Questions to be resolved re helipad SMP

Below is a note of what I think are the key (more technical) issues that need to be resolved. I am using this list as a basis for a discussion with our Peer Reviewer and you may want to discuss these with your consultant.

NOTE OF KEY ISSUES

Figure 1 - Mean Measured DNL, Summer 2018

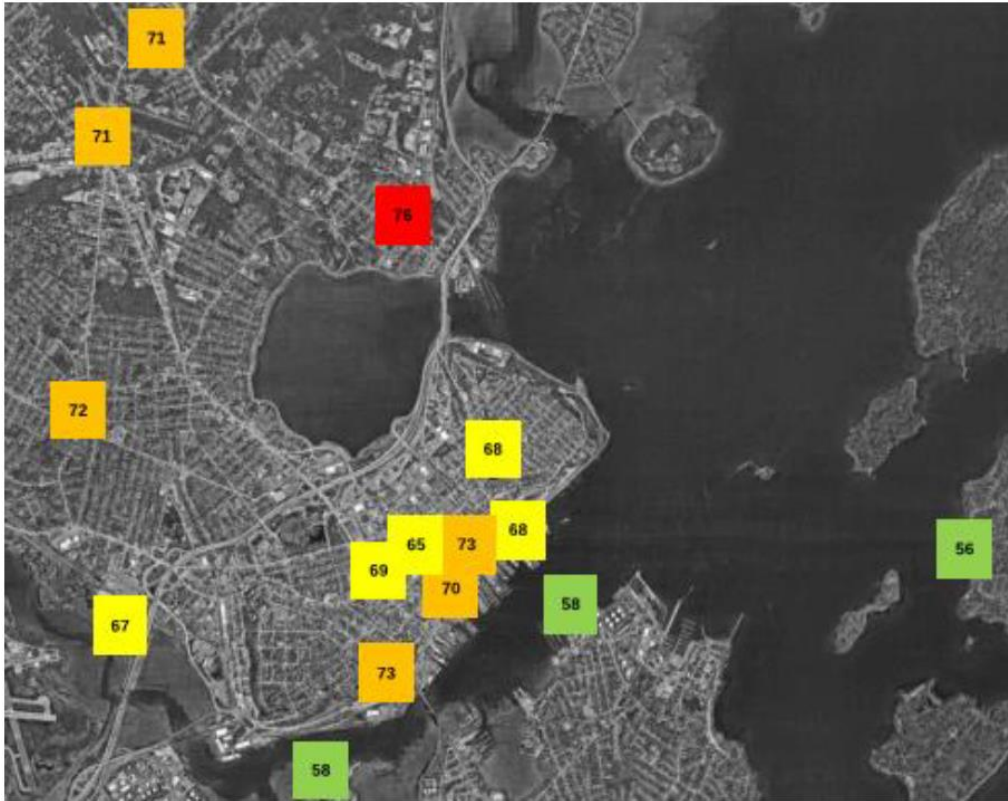
1. MMC consultants focused on comparing test data with historic info for the measuring points associated with assessment of the first helipad, and they show that the sound from helipads generally less than ambient (not clear what times of ambient measurements are in the table). City is seeking comparison of the sound of the existing helipad with the relocated helipad (same ambient), and for properties previously not impacted. Can the existing data be recast to show this? Do we need to get data from Accentech?

Fig.4.5 Proposed Flight Routes for the new MMC Helipad

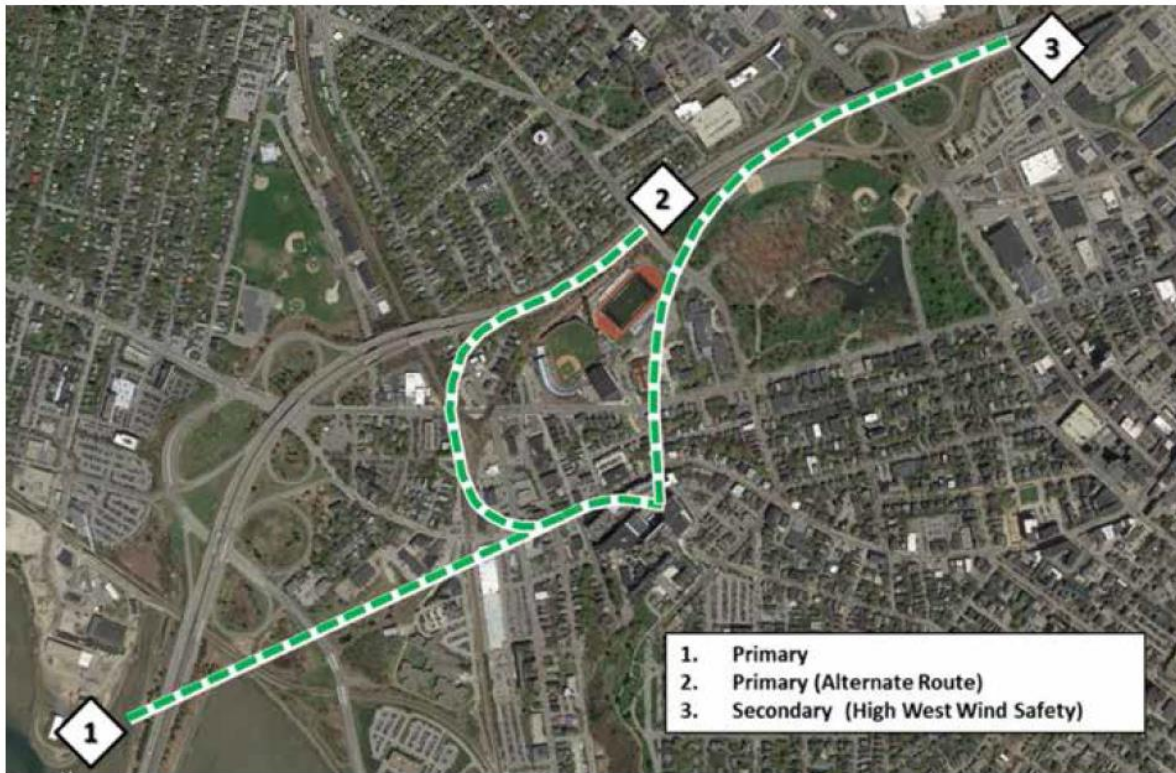
5. Local residents have asked about whether the secondary pad (nearer to them) has been tested re sound impacts? This is virtually over some of the houses. Is there data on how often this pad would be used? (DNL not applicable here as use will be very infrequent)

*Appendix 6: 2017 Sound Study Measurement Locations*

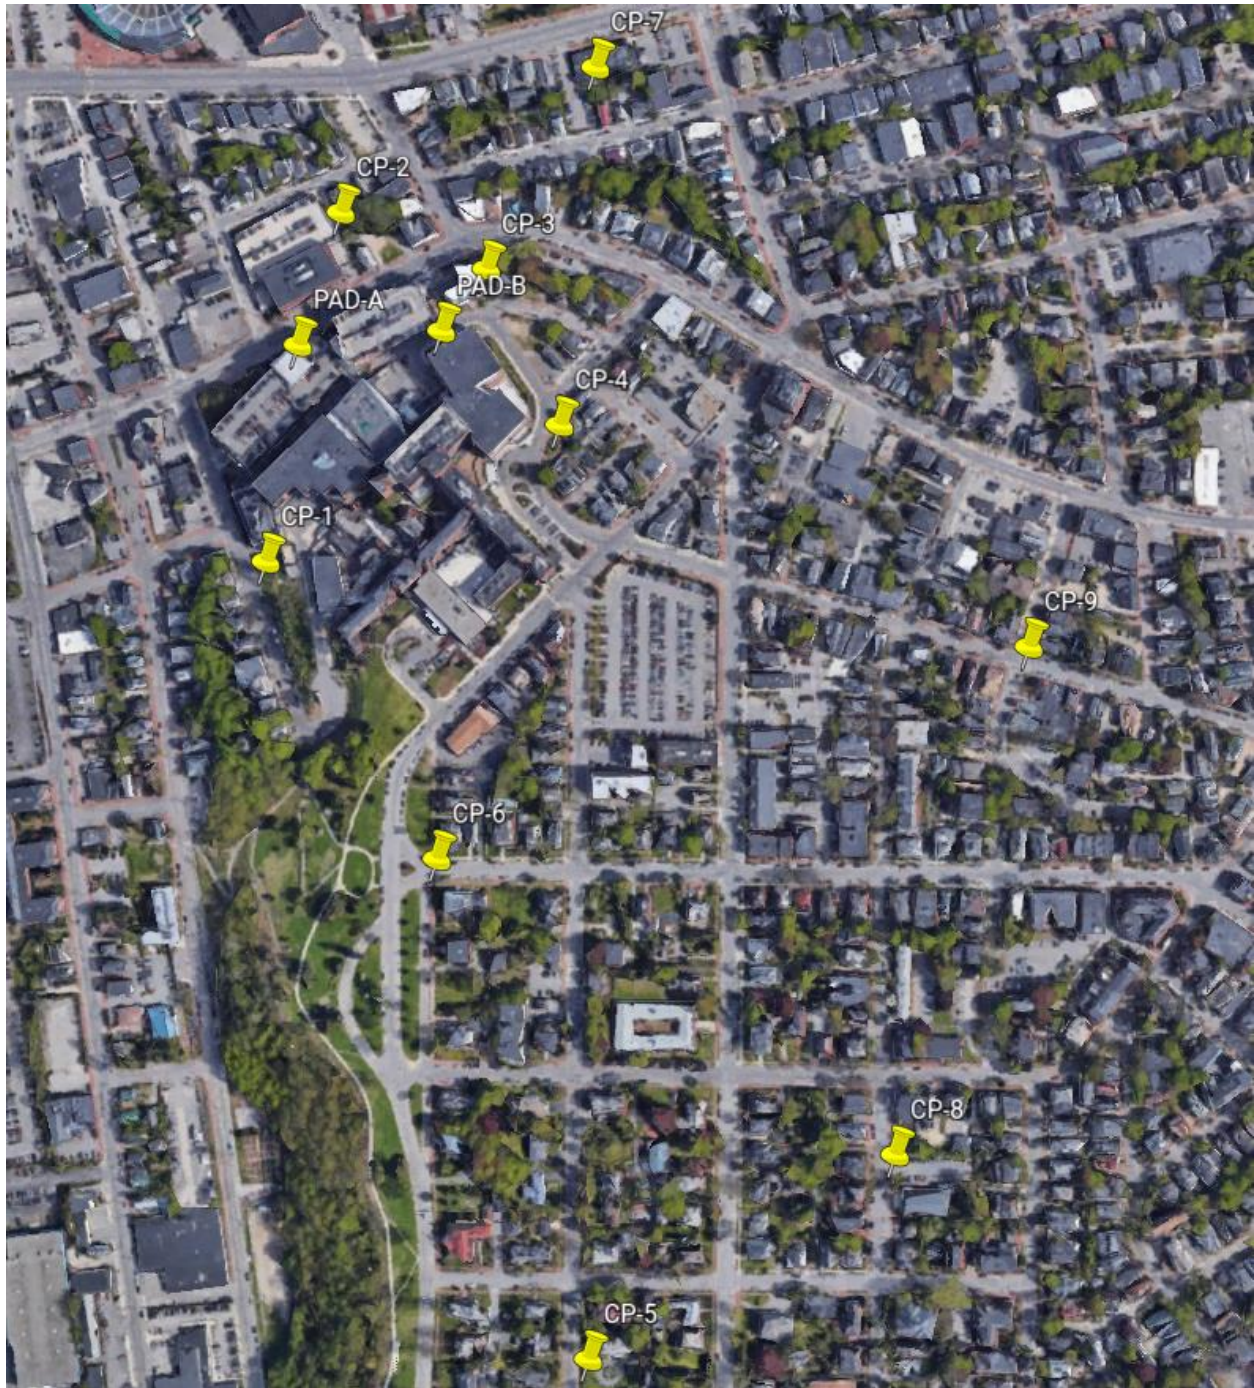
2. The City's Peer Reviewer recommended an additional measuring location (CP10), but it would require suspension of construction on East Tower and is so close to CP 3 and CP 4 it appears to add little information (as properties near it will be eligible for mitigation anyway). Can we omit CP10 ?

4. Local residents have pressed for the addition of a measuring point farther to the east to capture impacts of the relocated pad in horizontal direction and with apparently less shielding by existing buildings. In absence of further measuring, how can we create criteria for a complainant where there is no nearby measuring point? Can the sound impacts be modelled? Or a “cone of potential impact” be described?

I believe additional locations are needed. I see a need for a line-of-sight measurement location in-between the radiuses of CP-4 and CP-6 and -9. The first represents a potential worst case location, which is useful, but CP-6 will have some building shielding, and CP-9 is significantly distant. Some middle-distance readings are needed, since this region of the West End is one that will likely experience a significantly changed sound pattern. With the loss of the sound-mitigation through building blockage that exists now, and a greater height, yielding line-of-sight and sound to hundreds more homes than the previous location, a significantly changed soundscape seems almost inevitable.
